**Wambo Mine  
Montrose Water Storage Modification11  
Environmental Assessment Review**

I refer to your email of 5 July 2012 regarding the Wambo Coal Pty Limited application to modify the development approved for the Wambo Mine which involves the construction and operation of a 1,500mega litre water storage dam. NSW Trade & Investment, Regional Infrastructure & Services, Division of Resources & Energy (DRE) has reviewed the *Montrose Water Storage Modification Environmental Assessment* (EA) dated June 2012 and provides the following comments which are directed at specific areas of DRE responsibility for this proposal.

Figure 3 - Proposed layout of Montrose East Dam

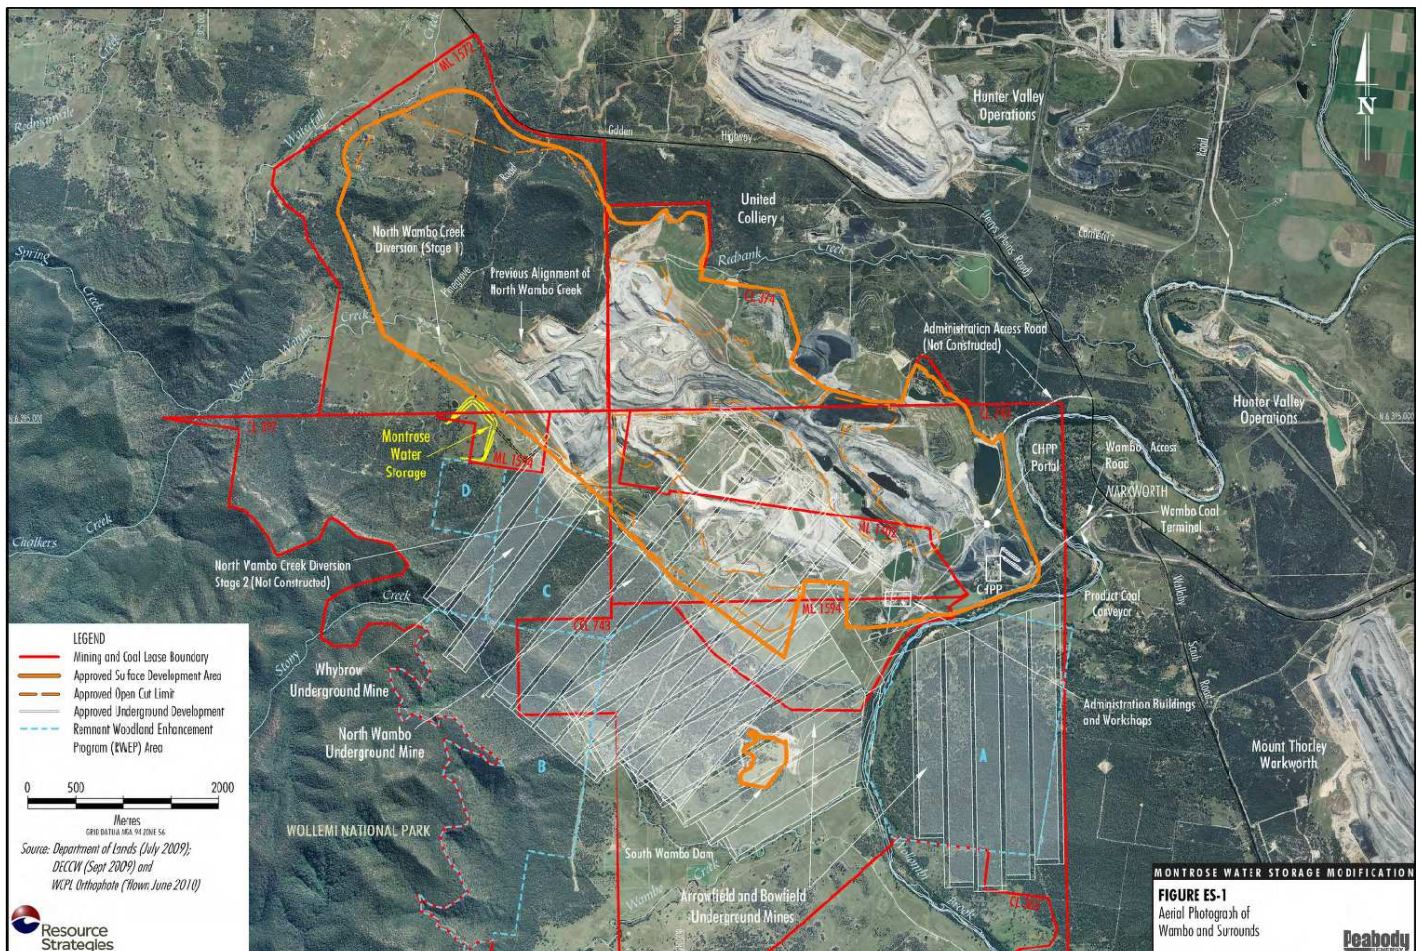
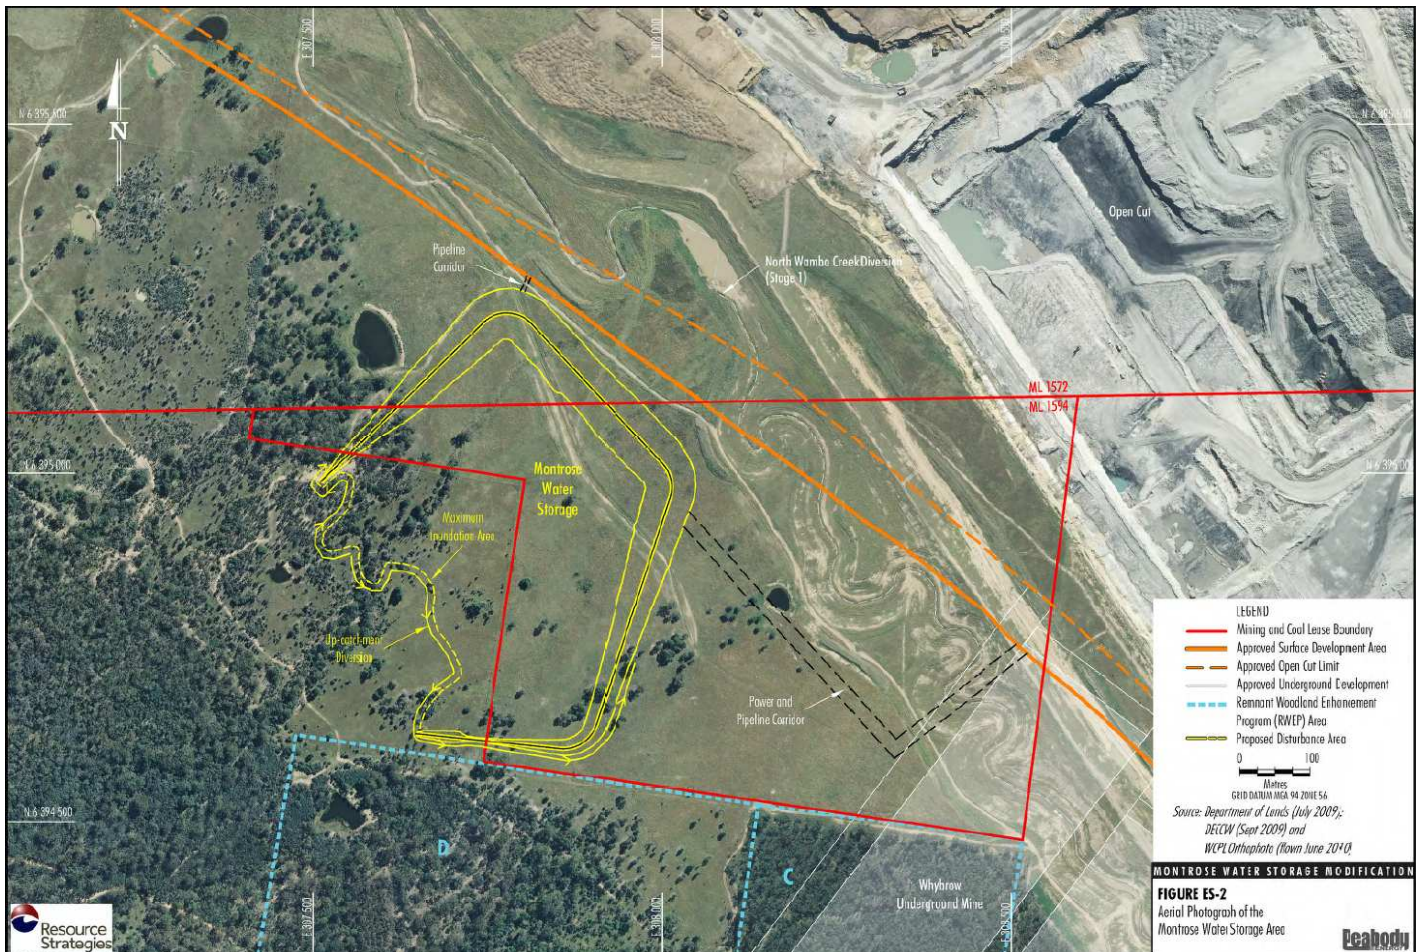
There is an area outside ML1594 which appears to have parts of the water storage walls, and includes the "Maximum Inundation Area" and the "Upcatchment Diversion" to which the proponent has no surface coal title. CL397 underlies this area from 15 metres below the surface. A mining title is required from the surface to 15 metres below the surface if the proposed dam is for mining purposes. This would require Ministers Consent prior to lodging an application. DRE notes that the land is owned by Wambo.
